File Number: SSD 7874  
Our Ref: R/2016/41

**Concept Proposal for the Redevelopment of Harbourside Shopping Centre, 2-10 Darling Drive, Darling Harbour – (SSD 7874)**

The City has reviewed the proposal and objects to the SSD for the concept proposal for the redevelopment of the Harbourside Shopping Centre to provide a new retail shopping centre, residential apartment tower and public domain improvements. We make the following comments:

Event space + Palm Grove

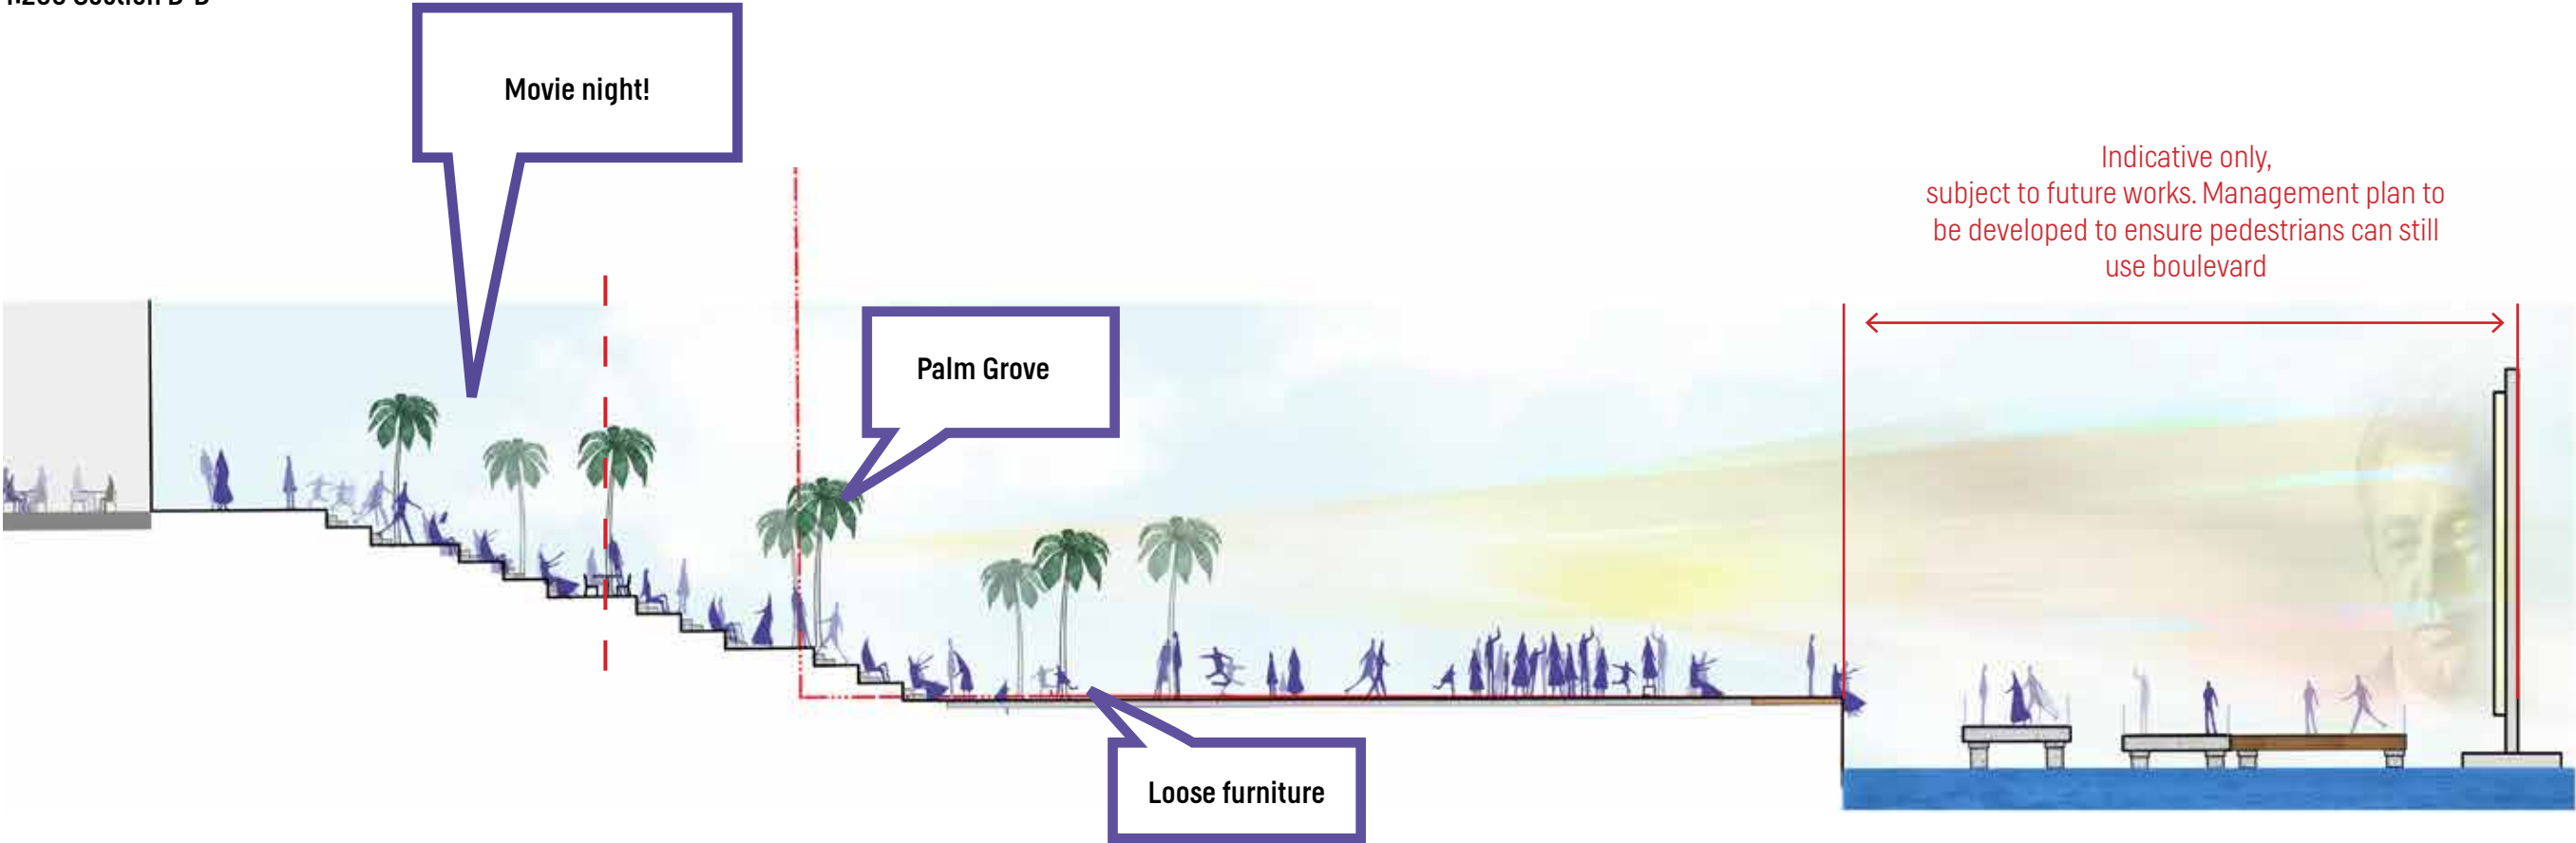
While this, concept proposal does not appear to include events it is noted that the outdoor cinema area shown on page 36 of the '*Public Domain Design Report*' shows the pedestrian boulevard to be fully obstructed. Pedestrian access along the waterfront should be maintained throughout all events. The walkway is to be clear and unobstructed at all times.

Figure 4.5.5 Pymont Bridge setbacks proposed

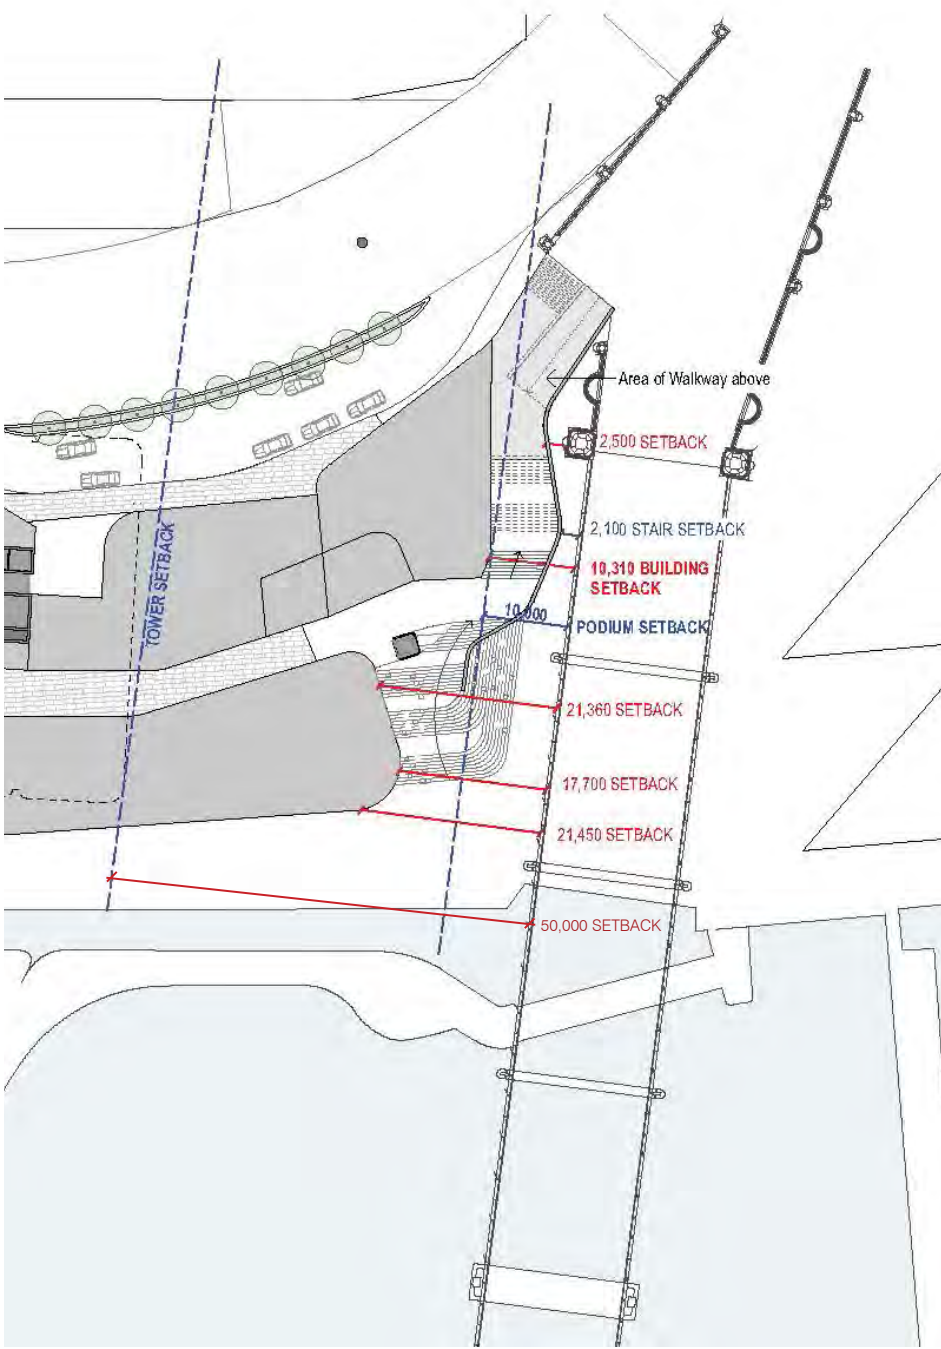
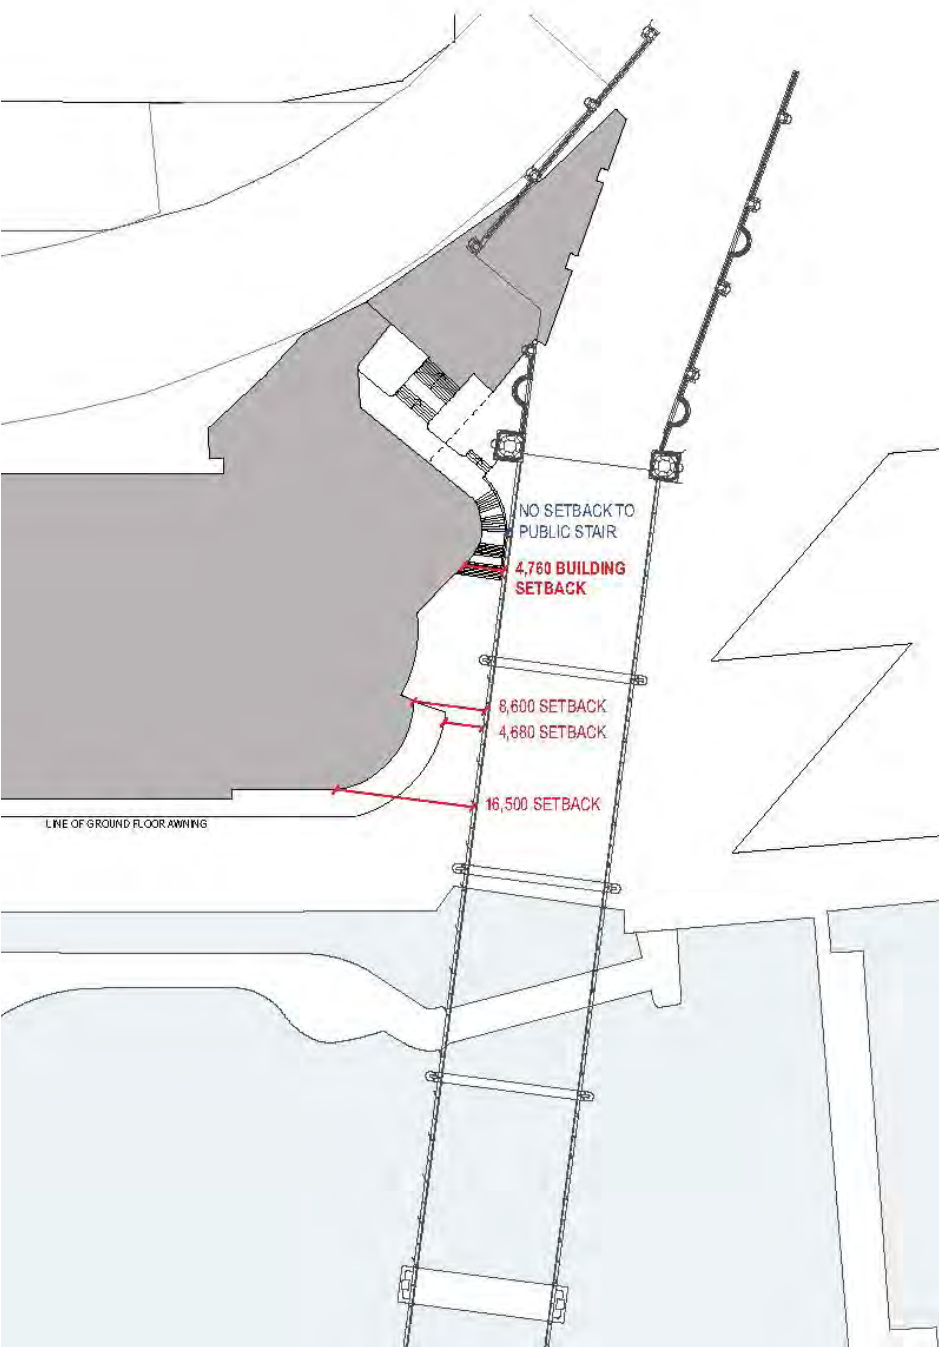
The proposed 10 metre setback of the podium and the 50 metre setback of the tower from the Pyrmont Bridge is considered insufficient to retain its heritage significance. In addition, these setbacks are inadequate to recapture the setting of Pyrmont Bridge and its approaches or to enhance and recapture view corridors in each direction between the Pyrmont Bridge approaches and the southern areas of Darling Harbour and central Sydney.

The proposed scheme is not consistent with the above policies. The diagram below from the architect's design report shows the upper podium levels breach the nominated 10.31 metre setback. The setting of the bridge remains compromised, and the space beneath the bridge remains insufficient, 'pit' like and overshadowed.

To be consistent with the above mentioned policies, it is necessary to enhance the view corridors in each direction between the Pyrmont Bridge approaches and the southern areas of Darling Harbour and central Sydney. This is only possible if the setbacks of the podium and the ribbon stair from the bridge are considerably increased.
